To: All Staff
From: Environmental Health
Date: 8/18/2026
Subject: SP-26-00007 Shultz

**SCHULTZ SHORT PLAT
PART OF SECTIONS 26 & 35,
TOWNSHIP 19 NORTH, RANGE 17 EAST, W.M.
KITITAS COUNTY, WASHINGTON**

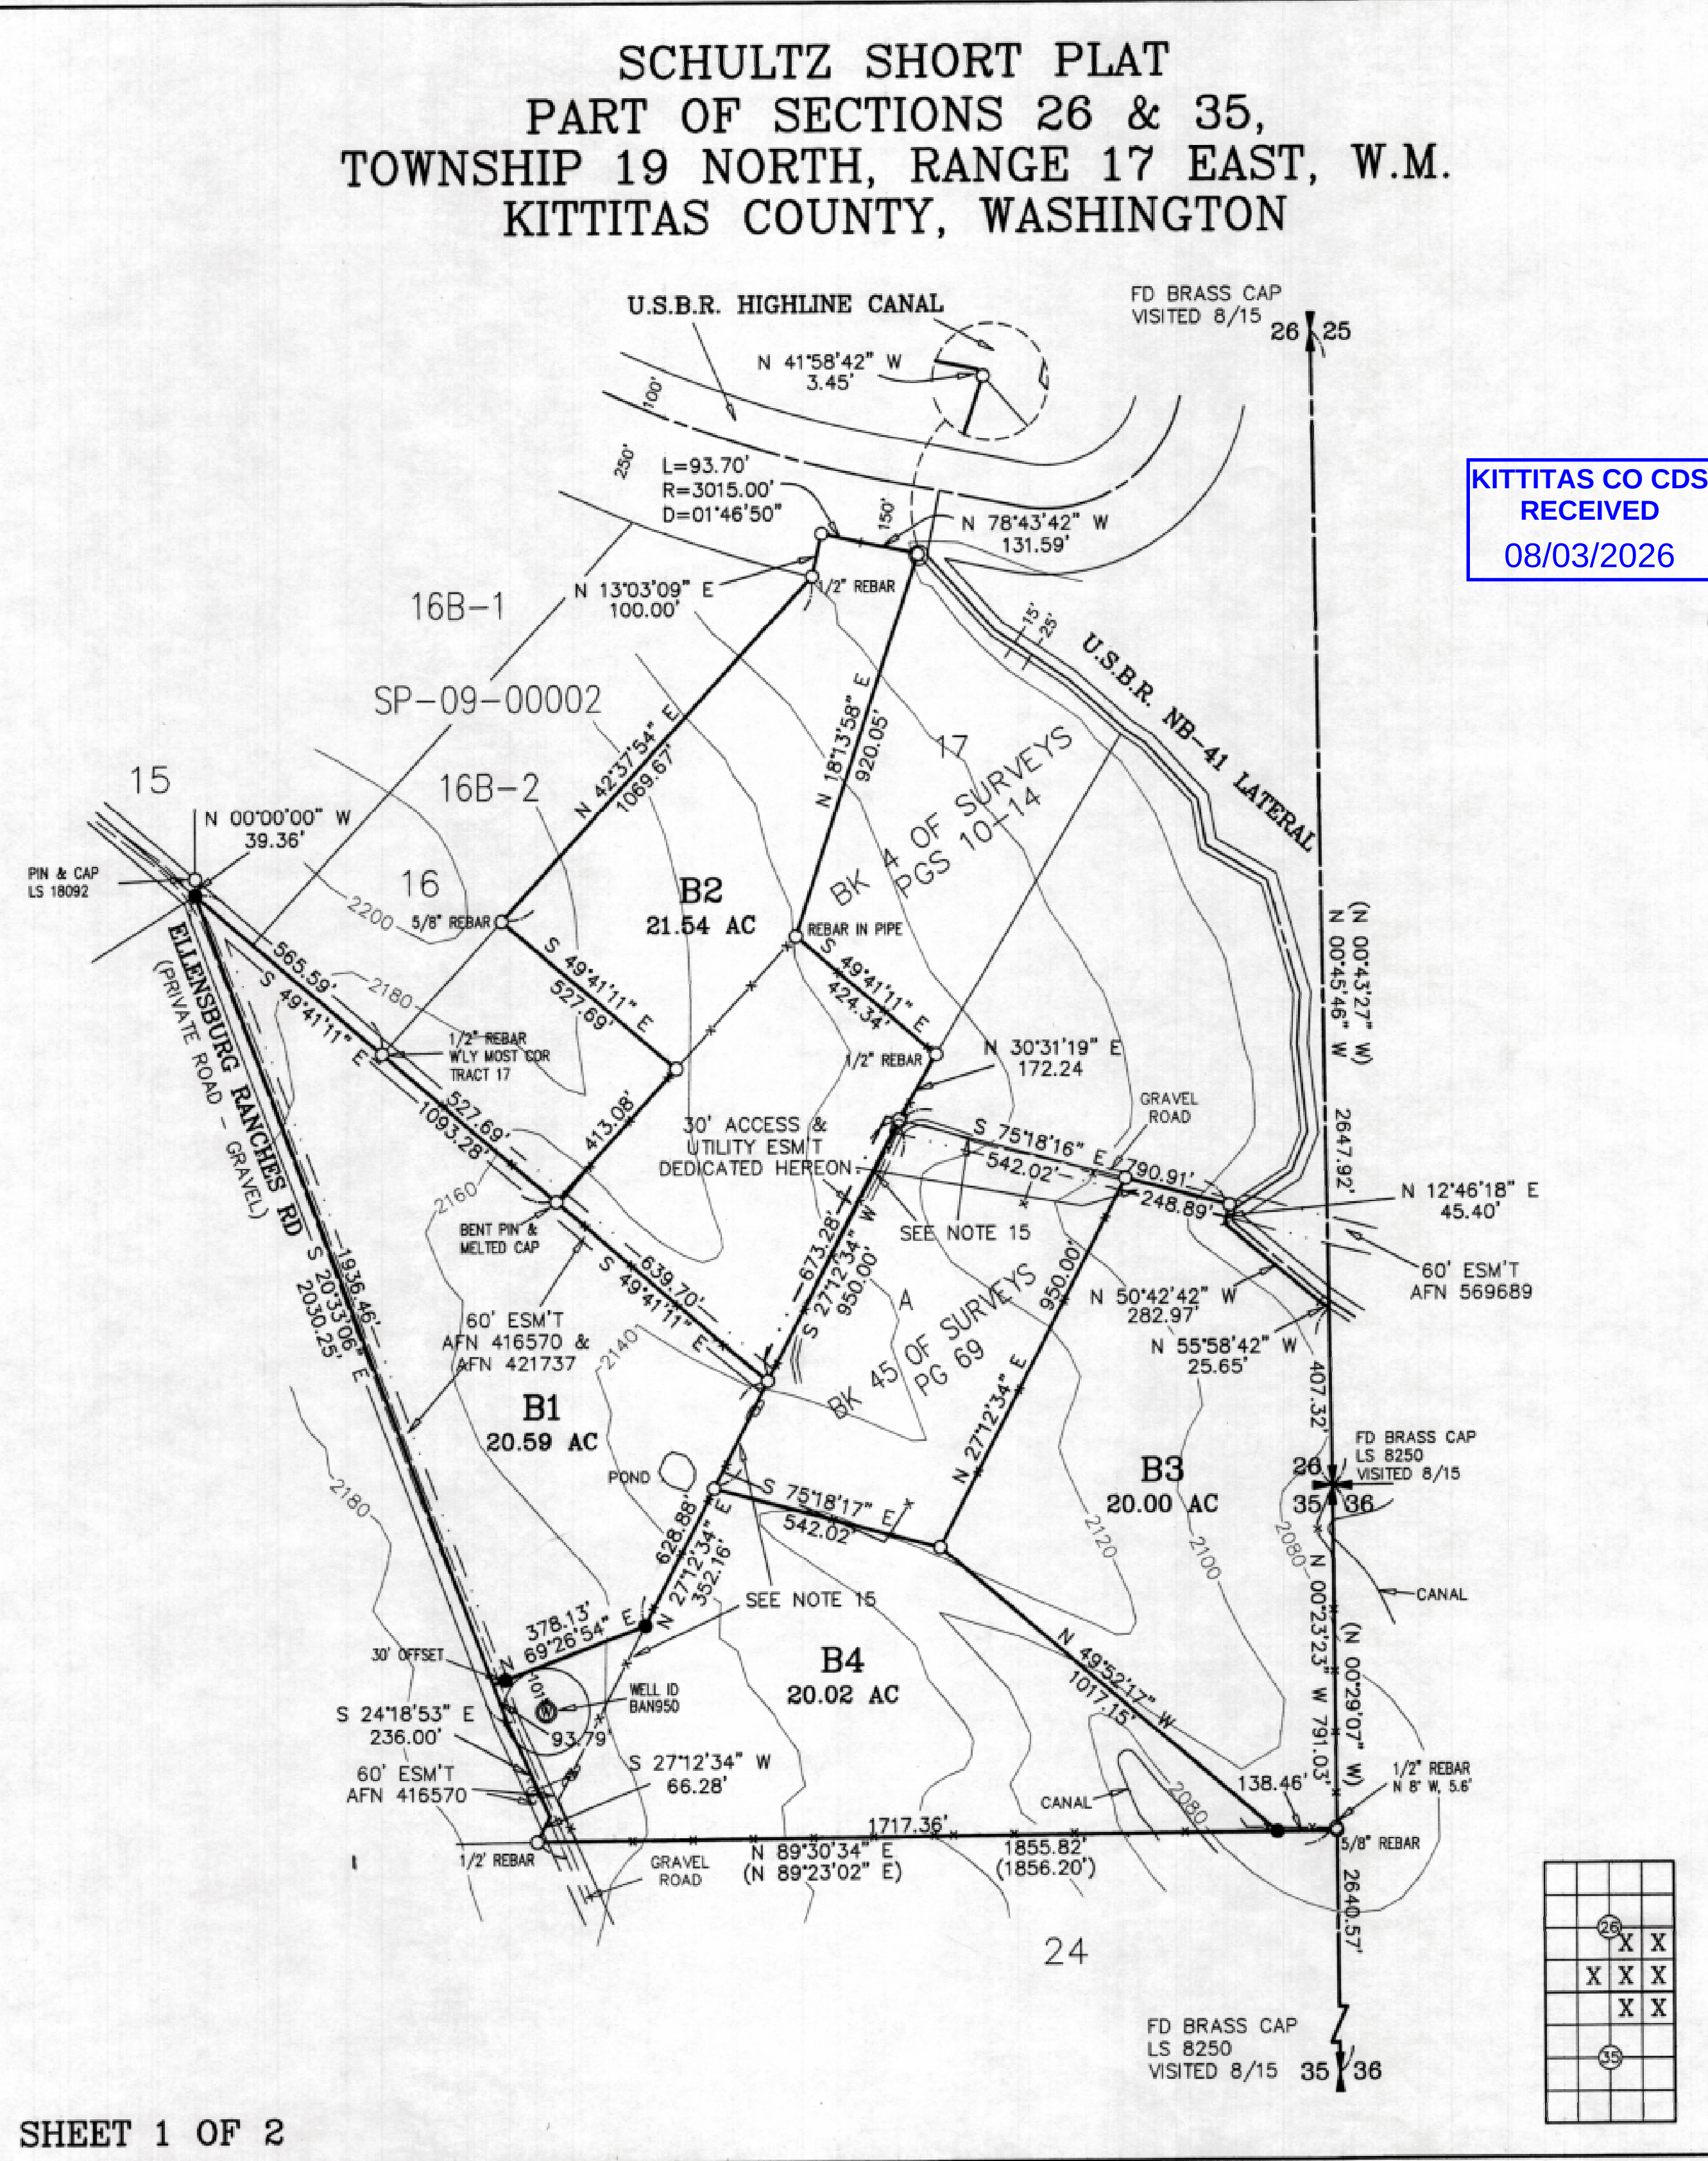
Drinking Water	• New wells proposed on the parcels will need to complete and submit a well site review application for approval of well site. • A water supply protection zone of 100ft radius for each existing or proposed well site for the parcels per WAC 246-272A-0320 (iii) • An AWSI I/S application is necessary for each proposed lot. AWSI I/S must have: Well log no older than 10yrs old or 4hr flow test, a current well water quality test which includes a passing bacteriological (within 1 year) and nitrate (within 3 years) result, recorded proof of mitigation and metering agreement, and site plan. • For any lot that intends to share a well a AWSI I/S application is necessary. The AWSI I/S must have the same documents as an individual well but includes a recorded well-shared users' agreement and if the 100-foot well protection zone overlaps with the adjoining parcel, include the site plan or as-built for the adjoining parcel.

Wastewater	• Soil logs must be completed for each proposed lot.
